116 Walton Street

Site Alteration

RE: 116 Walton St.

Response for Level 1 site plan submission – project Application ID: 2013-169

1 Detail 1 - site detail
A6.2 SCALE: 1/2" = 1'-0"
0 1' 2' 4'

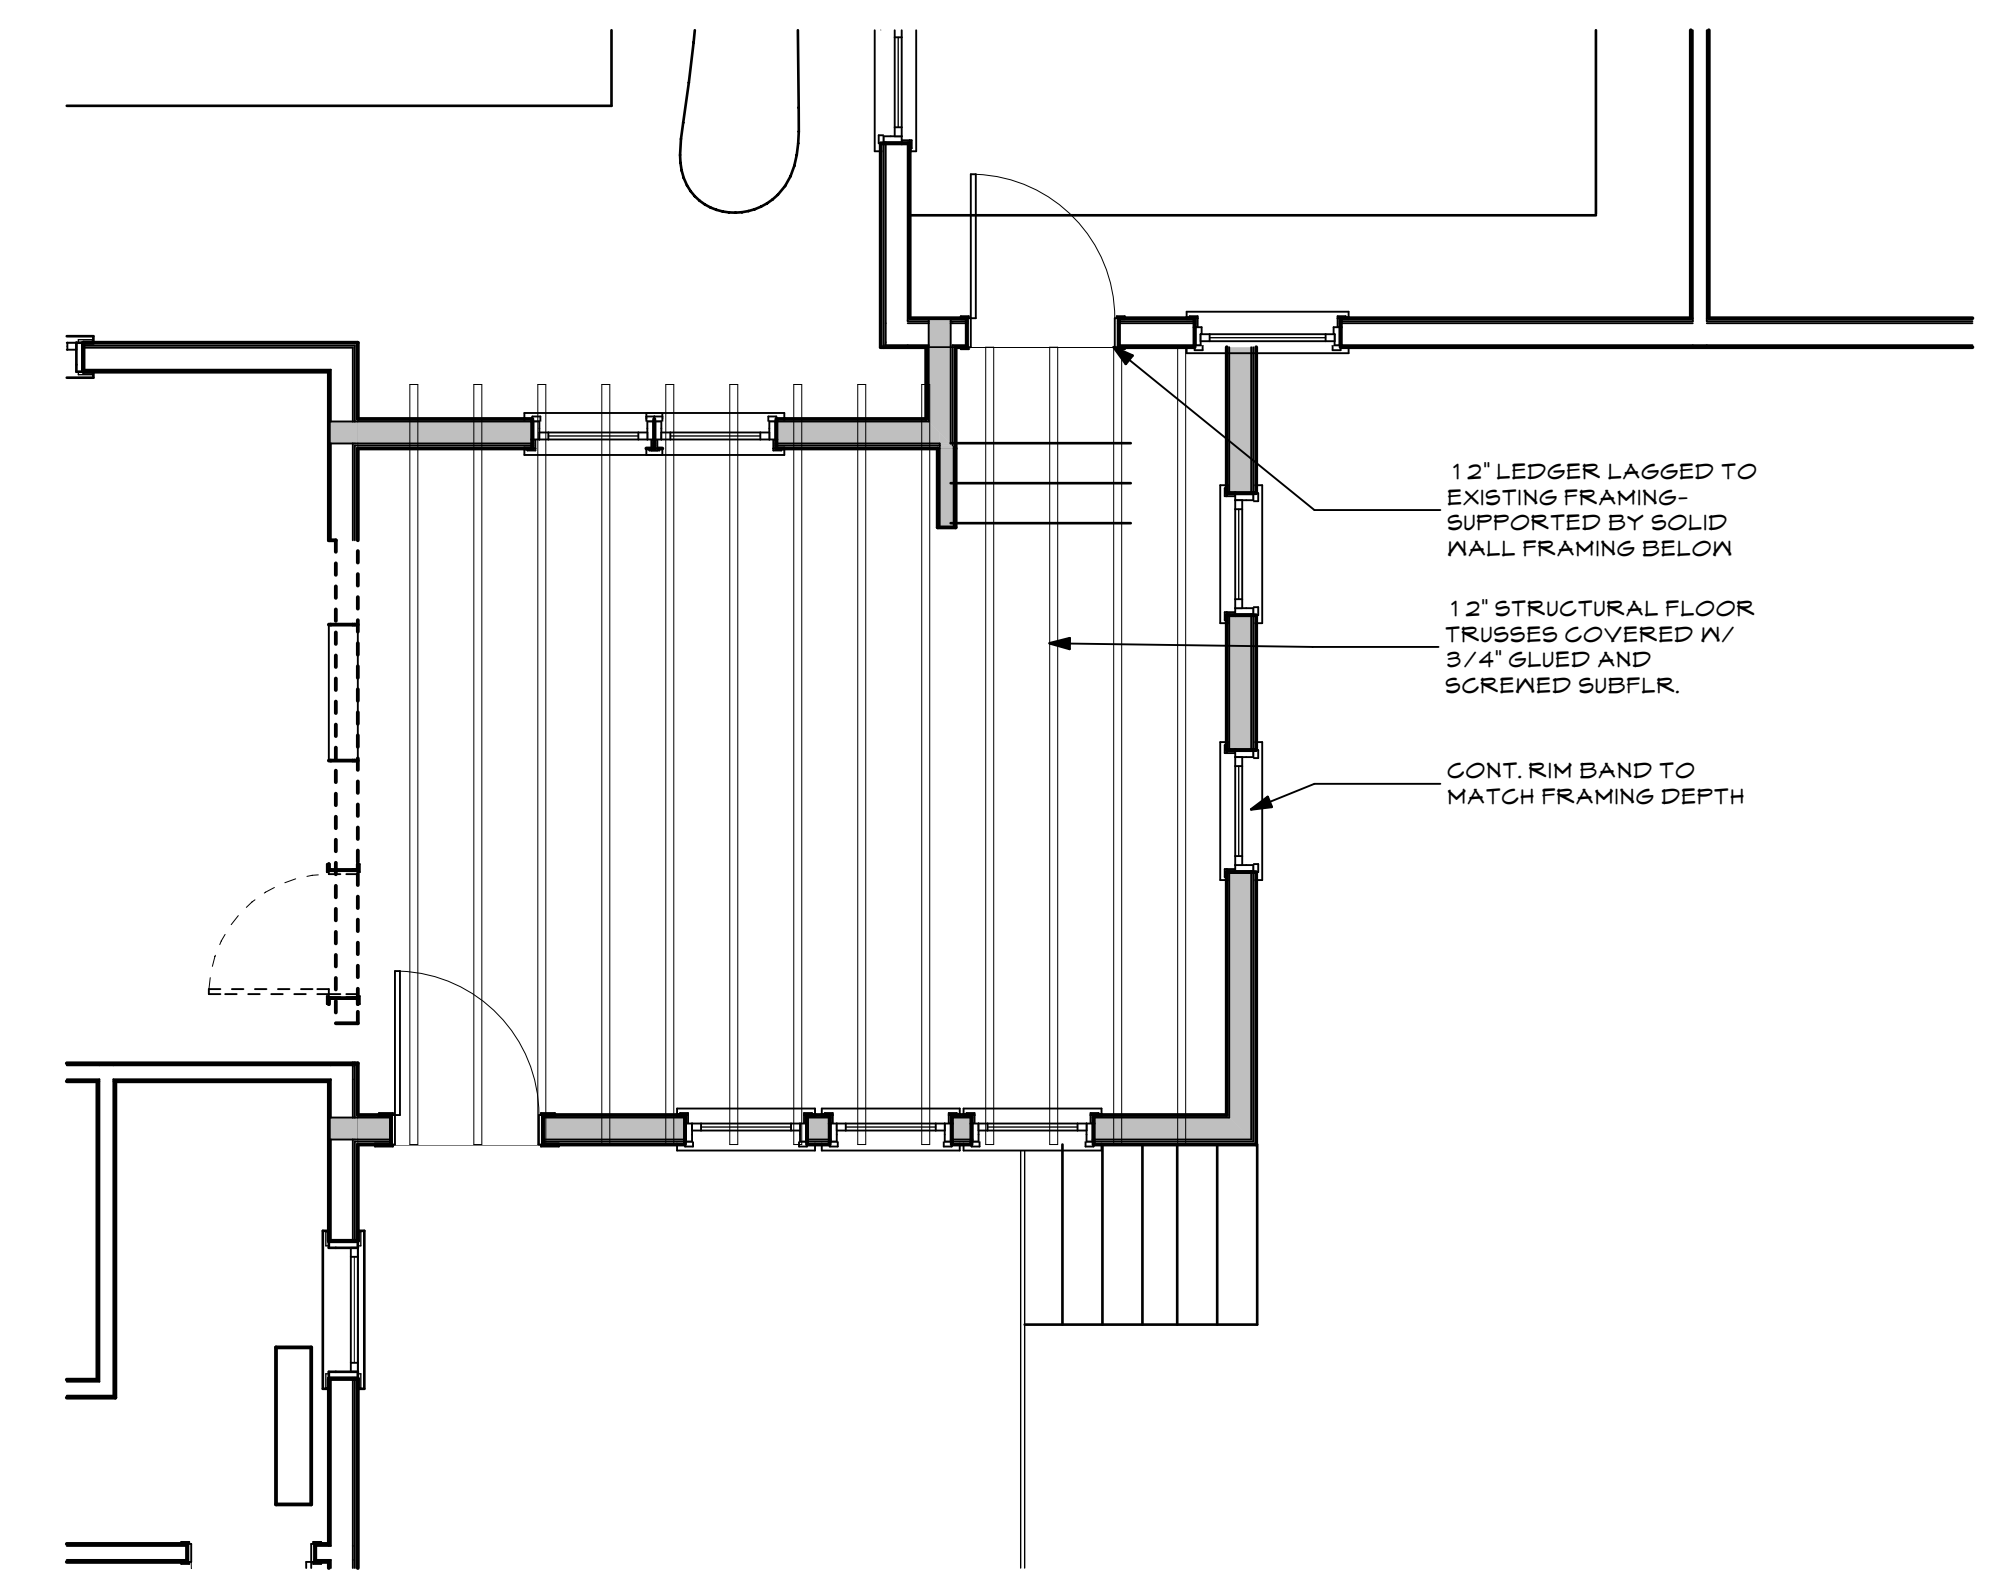
1. Basic Standard- Provide detail to address erosion and sediment control practices in accordance with Appendix A,B & C of Maine DEP Chapter 500. **Refer to attached detail.**
2. General Standard- Note location of BMP , drainage features, and or grading- provide detail.. **Please refer to attached site plan with noted elevations and topography. We are simply routing surface flow to the rear of the site.**
